**TOWER 2, LEVEL 23
DARLING PARK, 201 SUSSEX ST
SYDNEY NSW 2000**

10 July 2018

MODIFICATION TO CAMPBELL'S STORES, THE ROCKS (SSD 7056 MOD 2) – RESPONSE TO SUBMISSIONS

Drawing Title  
**ELEVATIONS**  
JPW Project Number  
**12006**  
Drawing Status  
**EA**  
Drawing Number  
**EA-A-2000**  
Revision  
**D2**

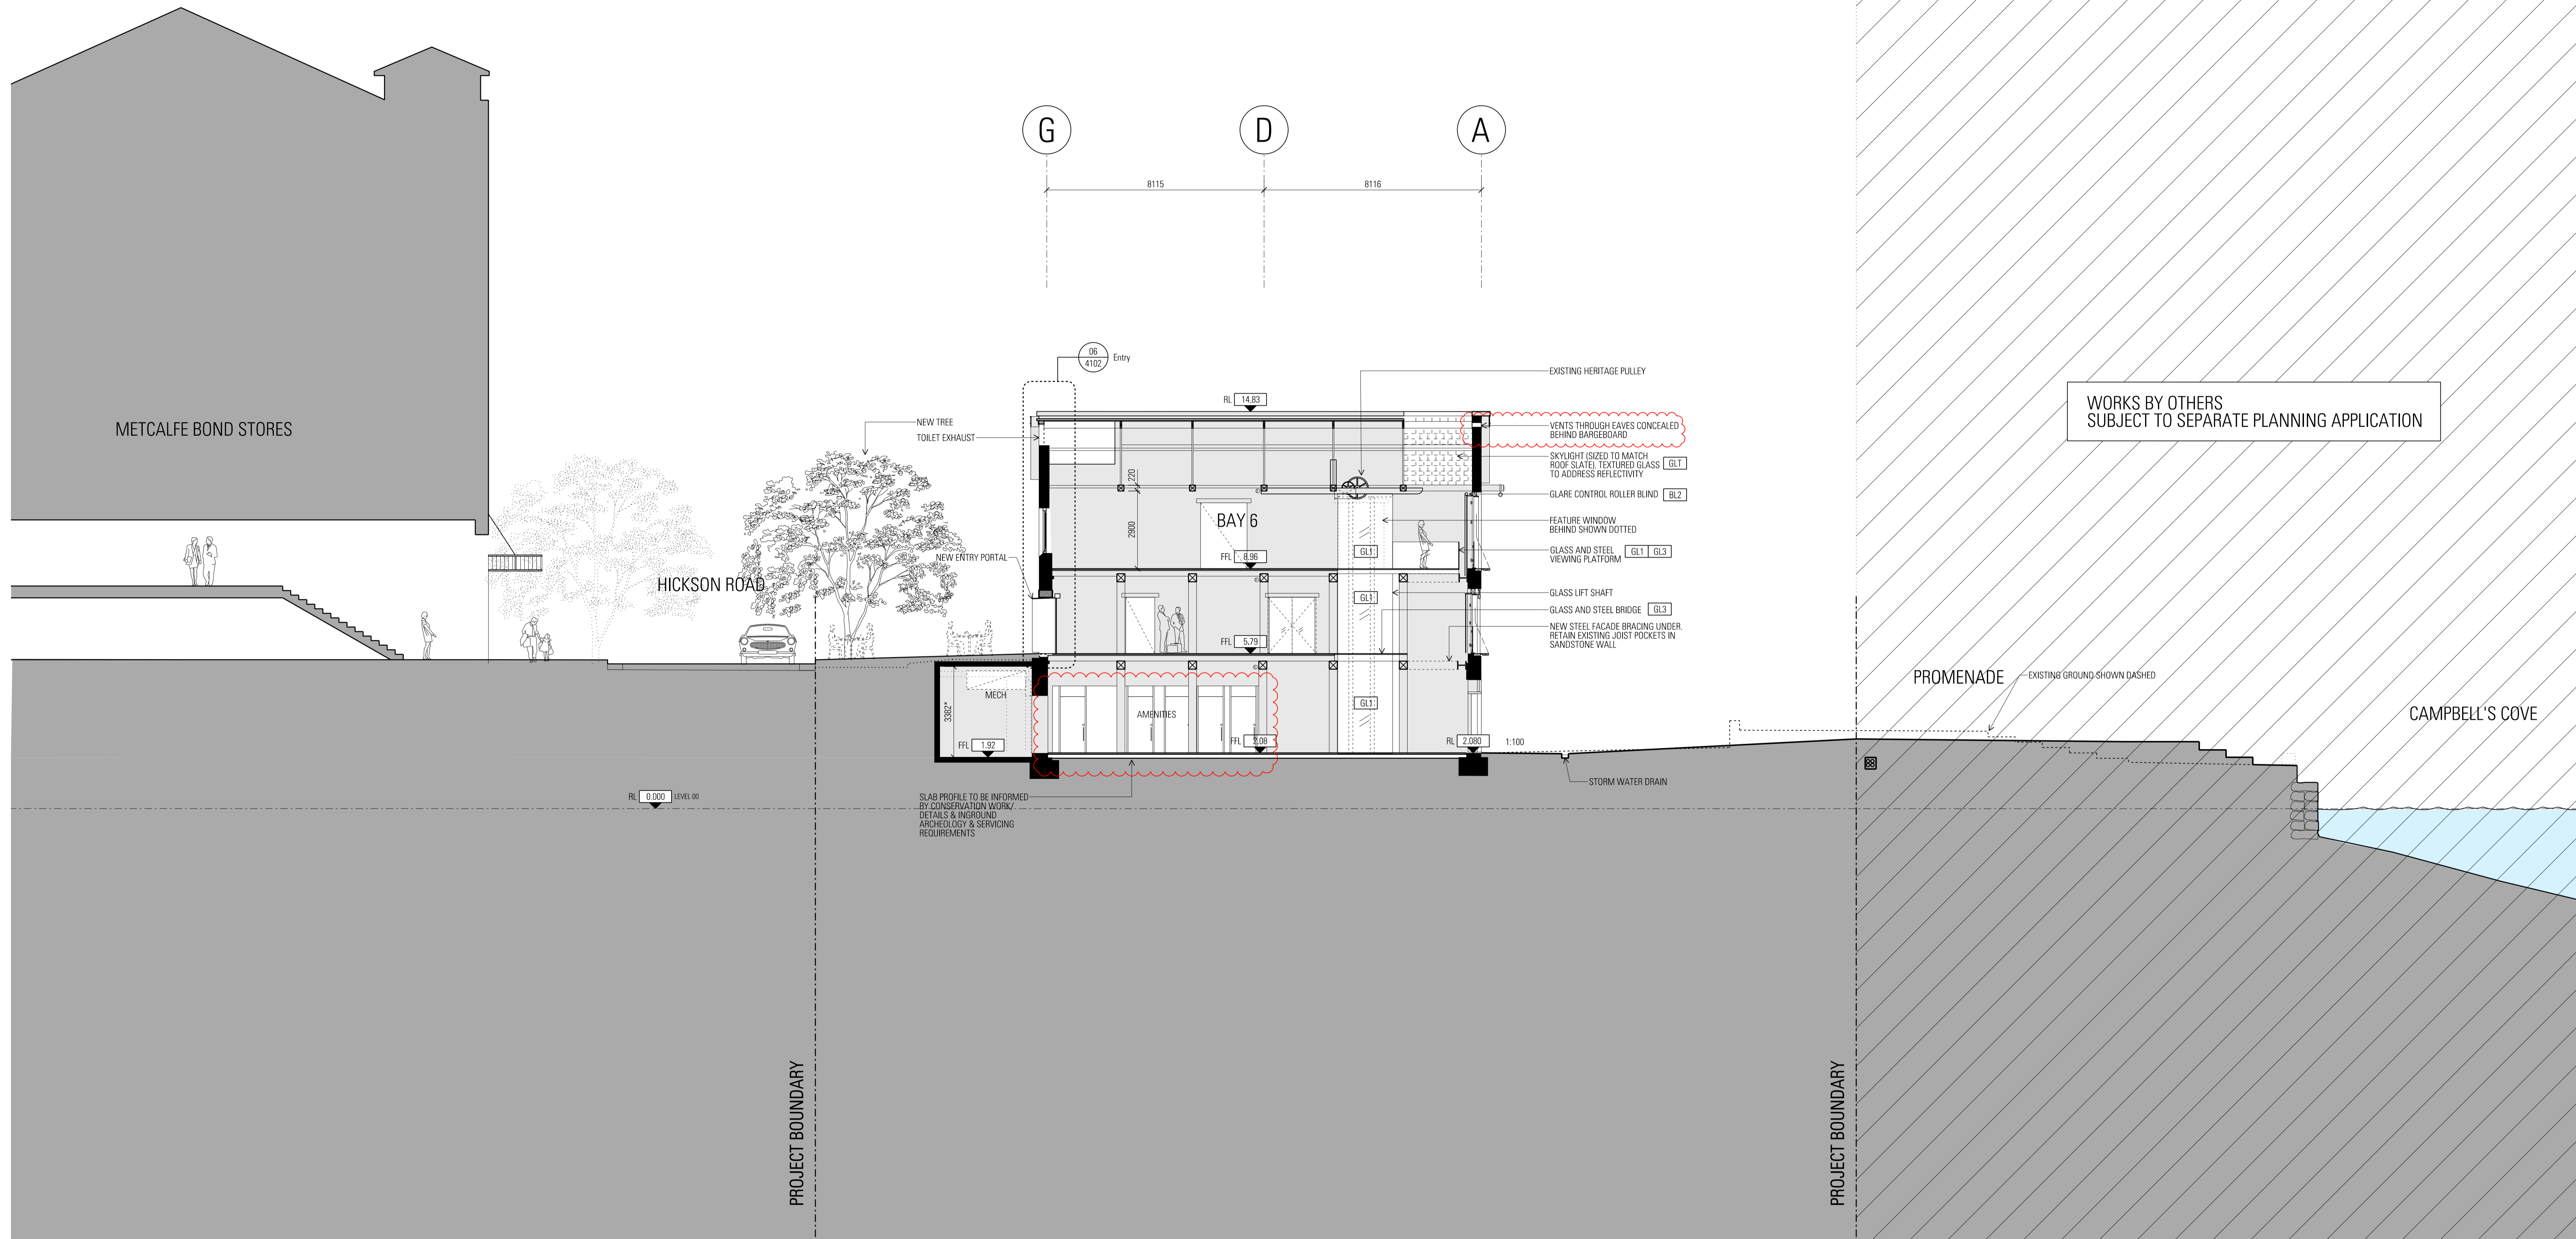
Submission	Response
<i>In addition, the architectural drawings EA-A-2000 & EA-A-3011 appear to highlight works to the eastern façade of Bay 11. However, these works have not been listed within the proposed scope of works and have not been assessed within the Statement of Heritage Impact. As it is unclear what is proposed, it is recommended that works to the eastern façade of Bay 11 are not approved at this stage.</i>	The Modification proposes to replace the existing dilapidated louvres and FC panel on the eastern elevation of Bay 11 with new alluvium louvres, powder-coated charcoal. The louvre is required to facilitate natural ventilation of the Bay 11 roof, whilst also protecting the building and brickwork from rain. The louvre design is consistent with the existing louvres found on the Hickson Road façade. The louvre replacement has been assessed by GBA Heritage (refer Attachment D). The assessment confirms the proposed replacement of the Bay 11, east Dutch gable front face with a new louvre will have an <u>acceptable heritage impact</u>. Specifically, the assessment states: • <i>Originally the Bay 11 roof was hipped, but altered to a Dutch gable, possibly after WWI.</i> • <i>The CMP Policy 8 guideline indicates that the Dutch gable can be altered to a hip if considered appropriate.</i> • <i>The Dutch gable has an existing flat sheet panel with what appears to be a later metal louvre.</i> • <i>The proposal is not to alter the form of the gable or barge boards, but to only replace the front face panel and louvre with a charcoal coloured aluminium louvre, thus improving air flow to the plant room.</i> • <i>The proposed modification of the gable front to a full louvre system, is therefore acceptable in heritage terms and a visual improvement.</i> Therefore, it is requested that the Department provide approval for these works, as detailed on the Architectural Drawings submitted with the application.
